Design Note

Response to Consultation on Application Number: 2017/90620 by Paul Farndale

This design note serves to provide a response to the comments provided by Paul Farndale on 27 March 2017. For completeness the original comments are listed above each response.

Title
FLOOD MODEL DRAWING

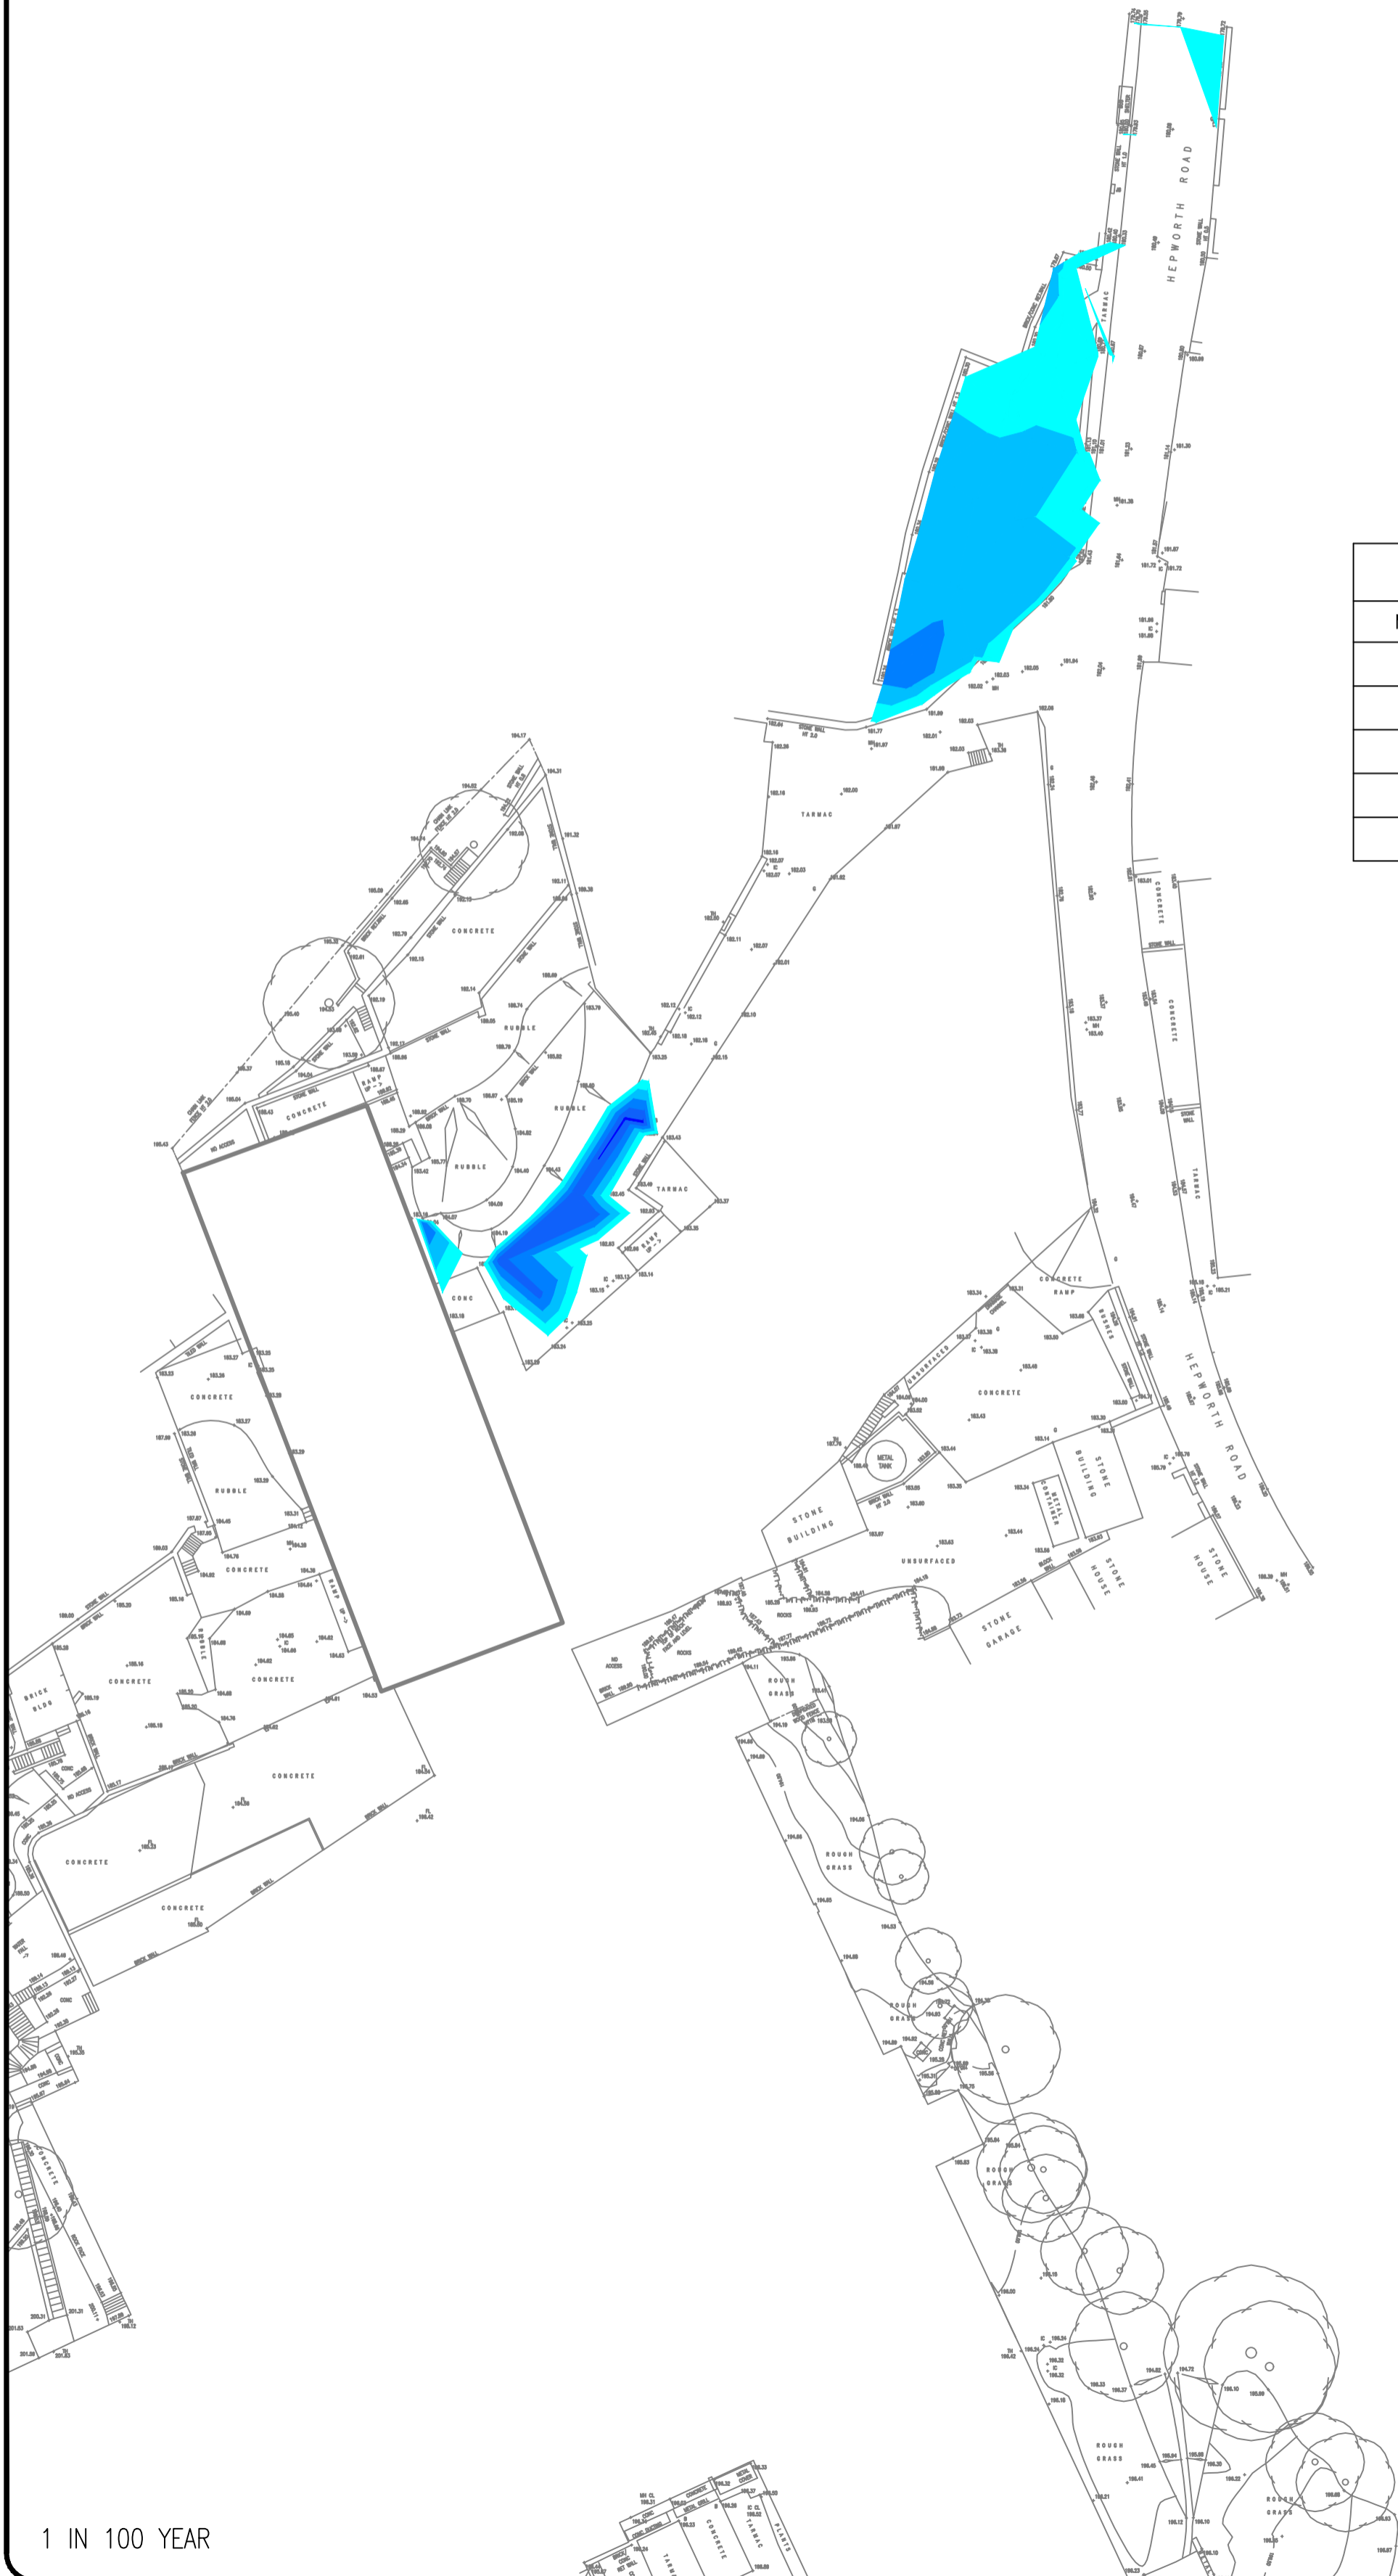
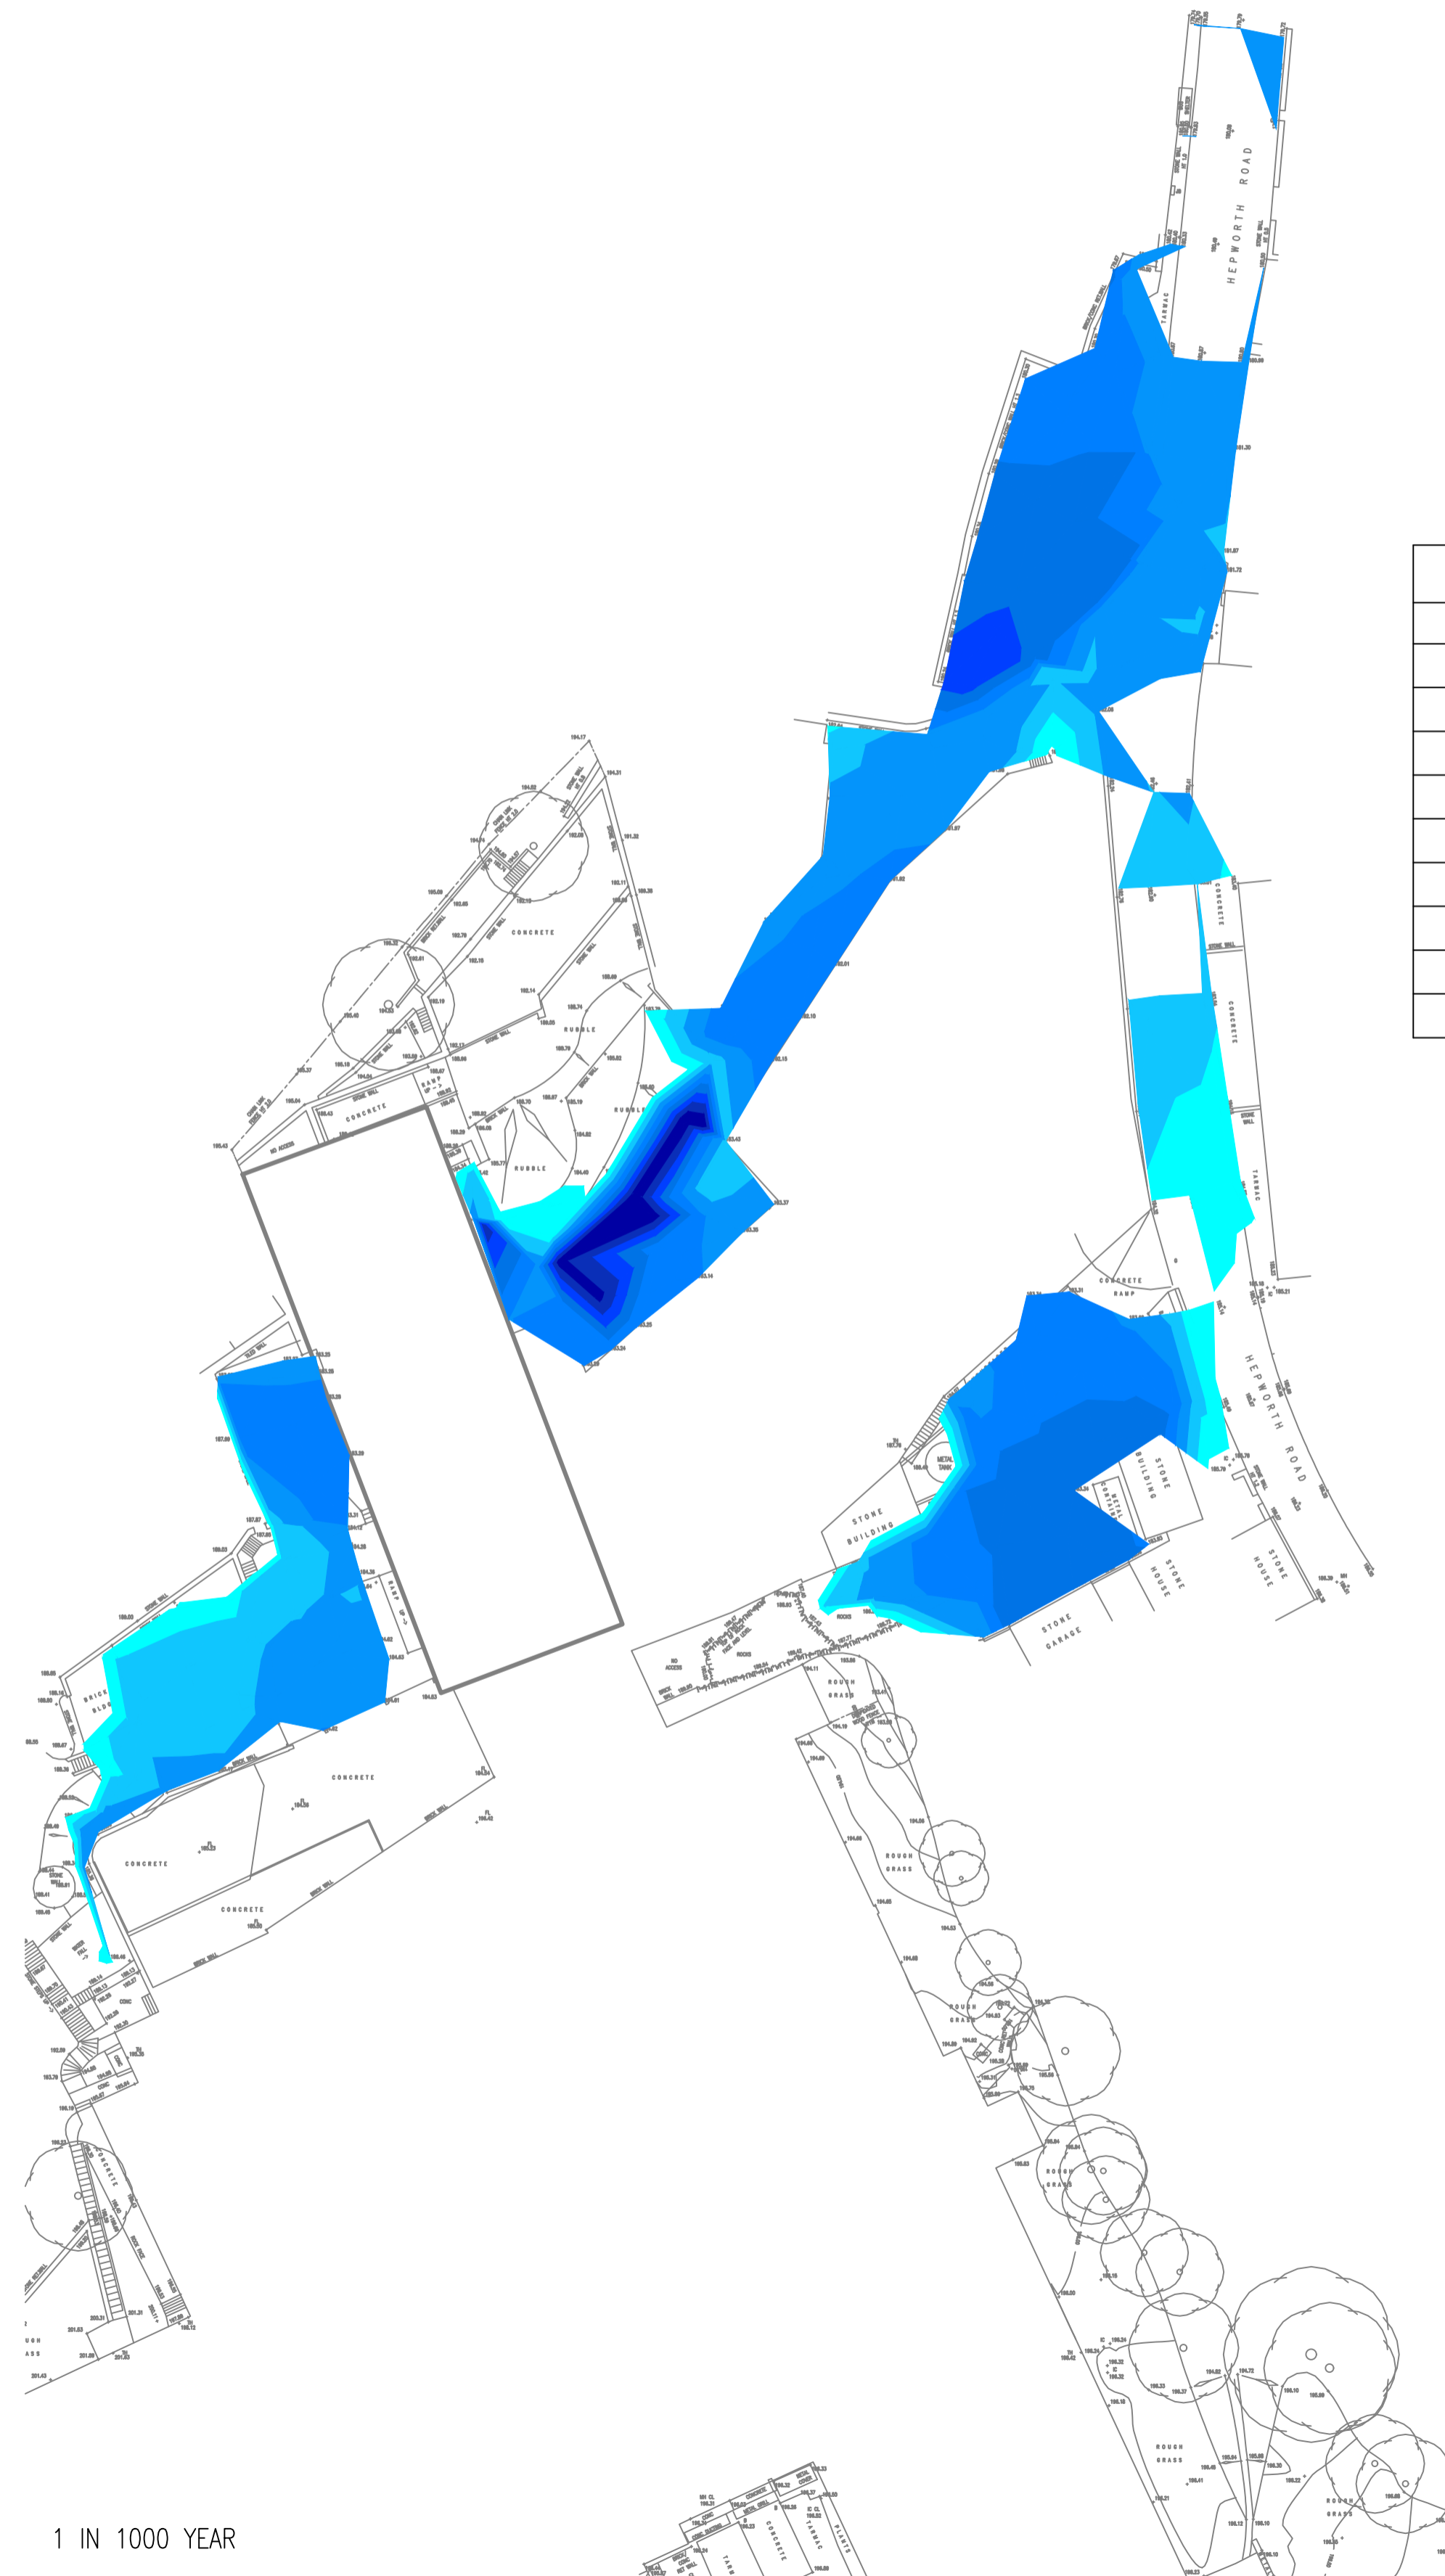
The flood risk assessment has included a small section relating to the mill pond. However there is no mention of the Lead Local Flood Authorities independent survey. There appears to be a significant disparity in the observations listed.

The Mill Pond Assessment provided in support of the Planning Application has been updated following a review of the assessments commissioned by Kirklees Council. Recommendations for further investigation, remedial works and long term maintenance have been made.
